KITTITAS COUNTY

MEMORANDUM

TO: Community Development Services
FROM: Taylor Gustafson, Environmental/Transportation Planner TG
DATE: April 23, 2019
SUBJECT: LPF-19-0004 (Palomino Fields – Div. V), also known as Cle Elum Pines

**LCU, INC.**  
Surveyed by LMH Scale 1" = 300'  
Drawn by Tml/FCS Sheet 1 of 5  
Checked by FCS Project No. 18146

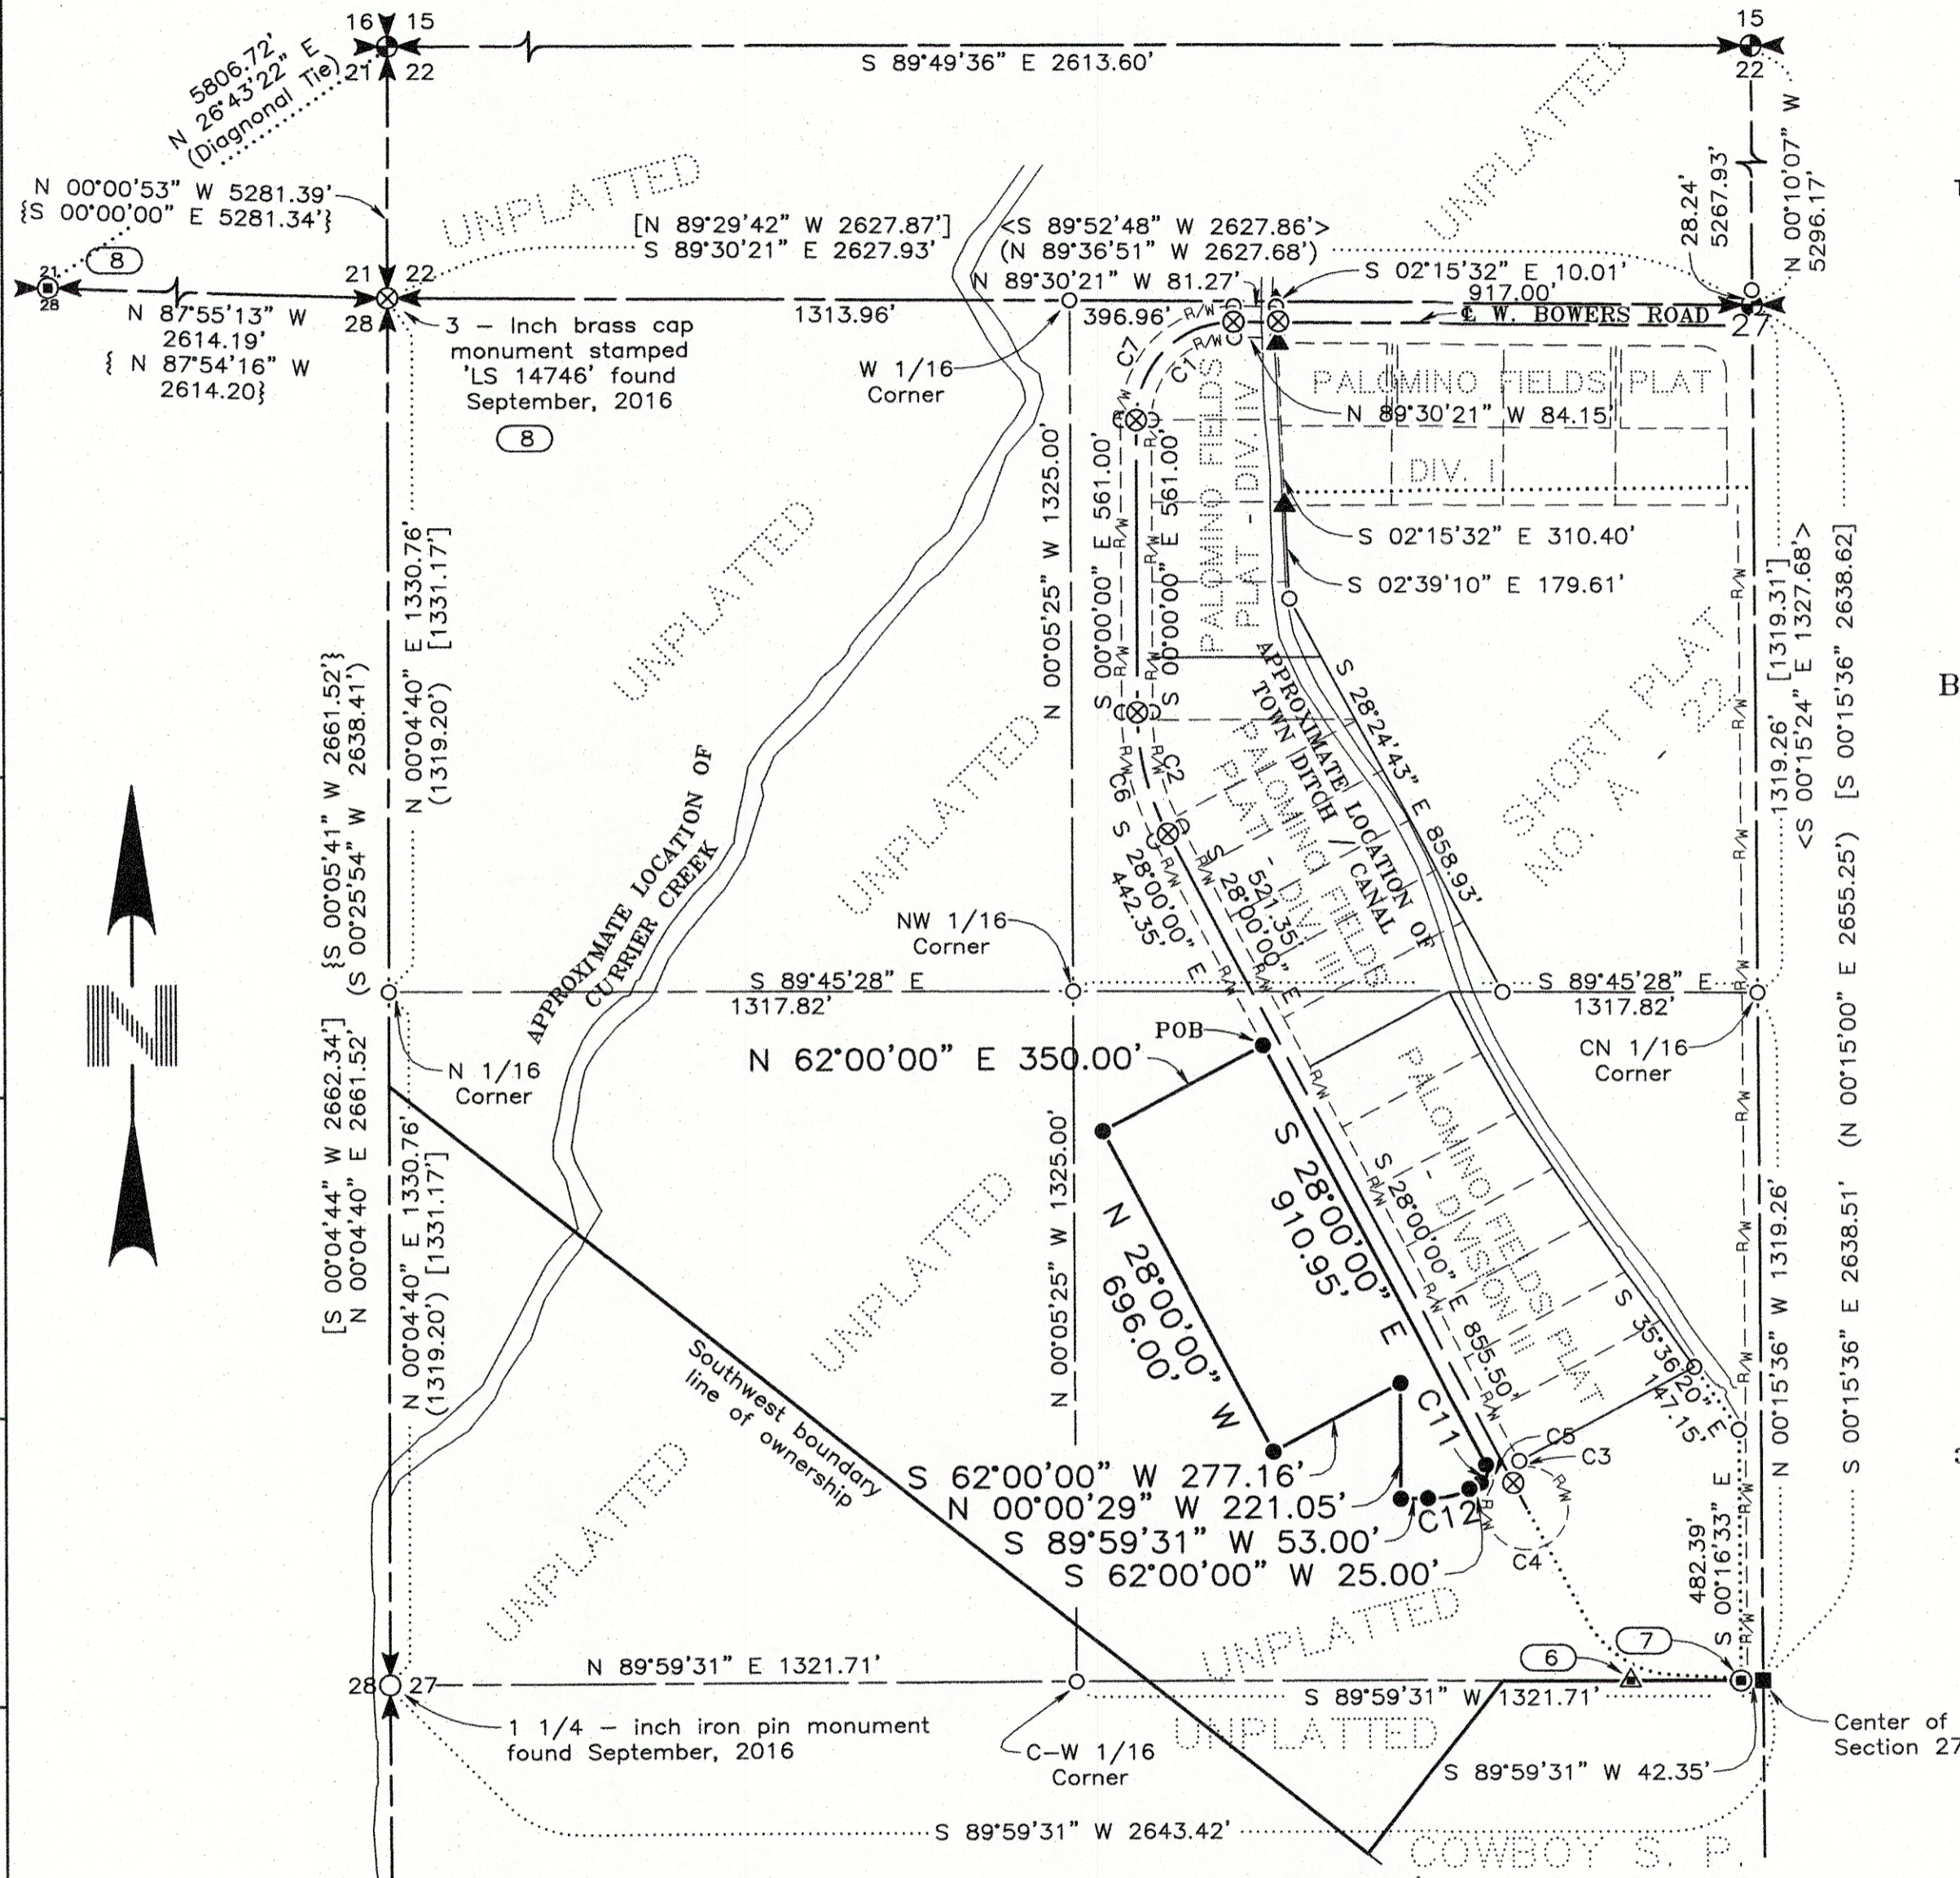
1. The exclusive use statement refers to the named parties in the Surveyors statement. There are no named parties in the surveyor's statement (multiple sheets).
2. There are multiple instances of line work obscuring text. (multiple sheets)
3. The proposed division actually involves a number of parcels, owned by two separate entities. The limits of all the involved parcels need to be surveyed with locations shown on the face of the plat. The concept of a "Parent Parcel" is the original lands involved, prior to proposed subdivision. The practice of outlining the project limits, and labelling them to be the parent parcel, is contrary to standard survey practice. Also note, that the remaining area of the involved lots will need to be labeled with a lot, parcel or tract name as well as an area.

Surveyed by: LKH Scale 1" = 100'
Checked by: Jm/f/FCS Scale 2" = 50'
Project No. 18146

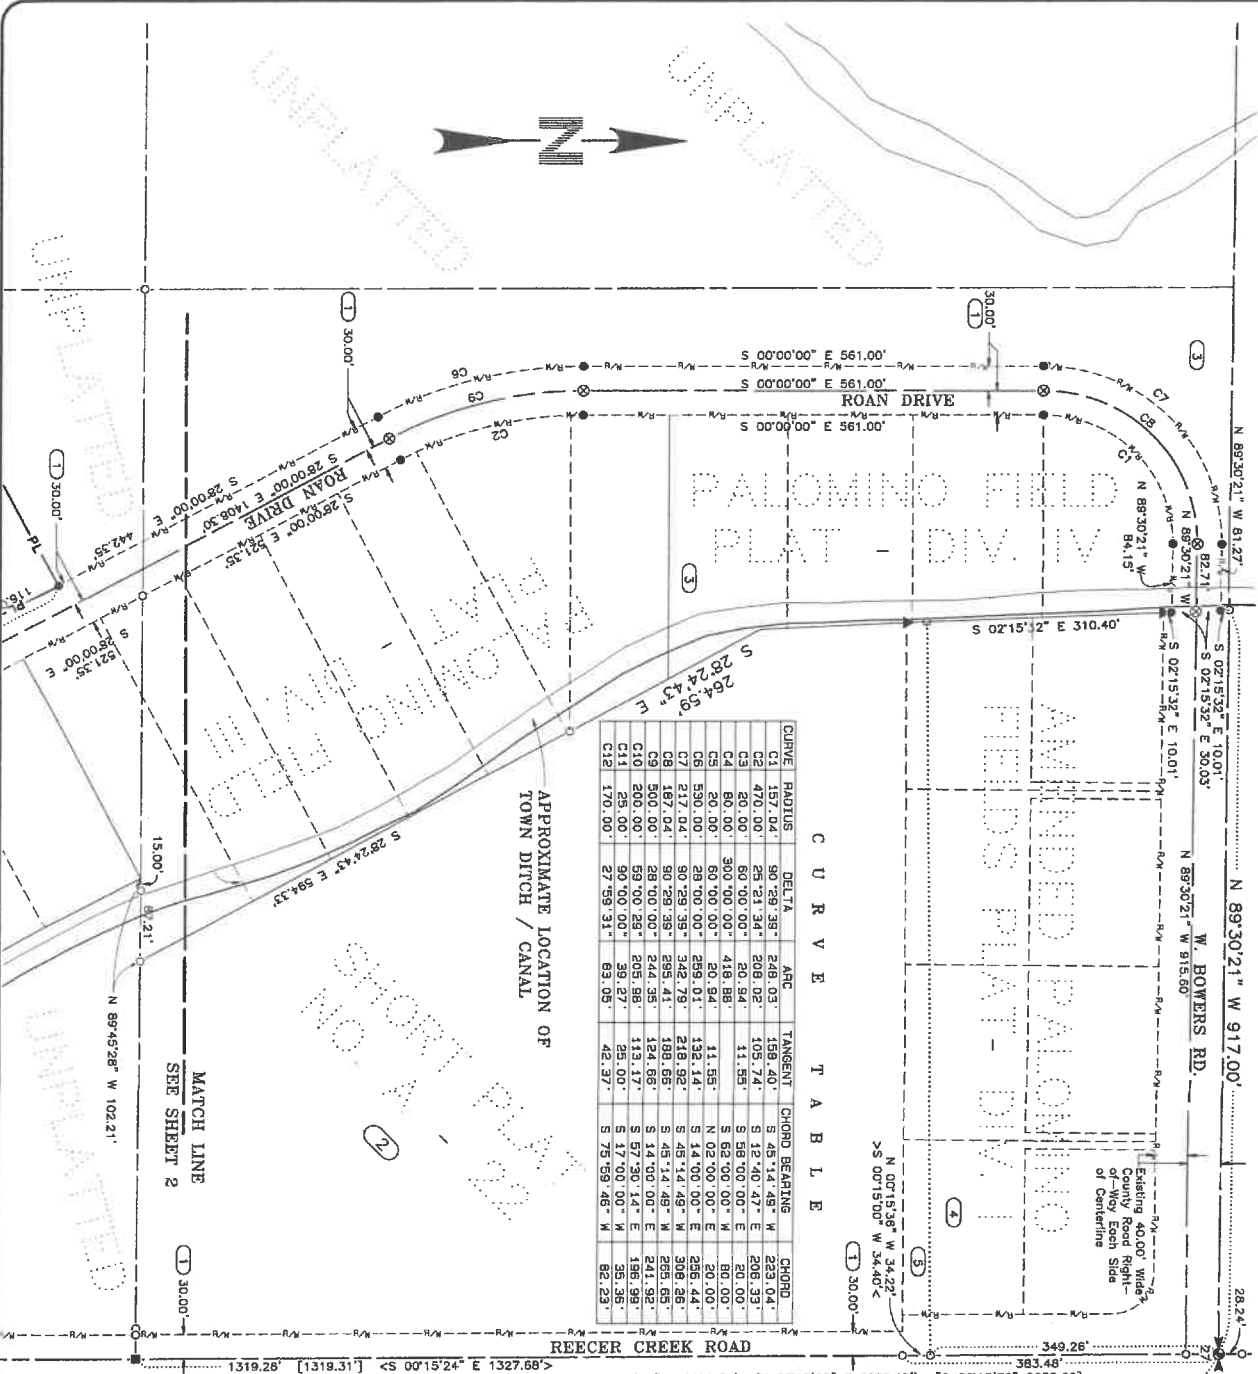
4. Remove the "more or less" from lot areas. As the lots are not bounded by a natural feature, nor are they of such a size that areas cannot be accurately depicted, there is no

- need to display the areas as approximate. If there is some mitigating circumstance that the areas cannot be accurately depicted on the face of the plat is should be noted.
5. In the legend, the text adjacent to the fourth symbol has a questionable date. If dates unknown, not labelling any date at all would be sufficient.
 6. The label of N00°15'36"W, 1.82' near the center of section is unclear as to what is being labeled. A detail window or note to clarify may be required.
 7. Minor spelling error on the description of Section line centered about Reecer Crk Rd.
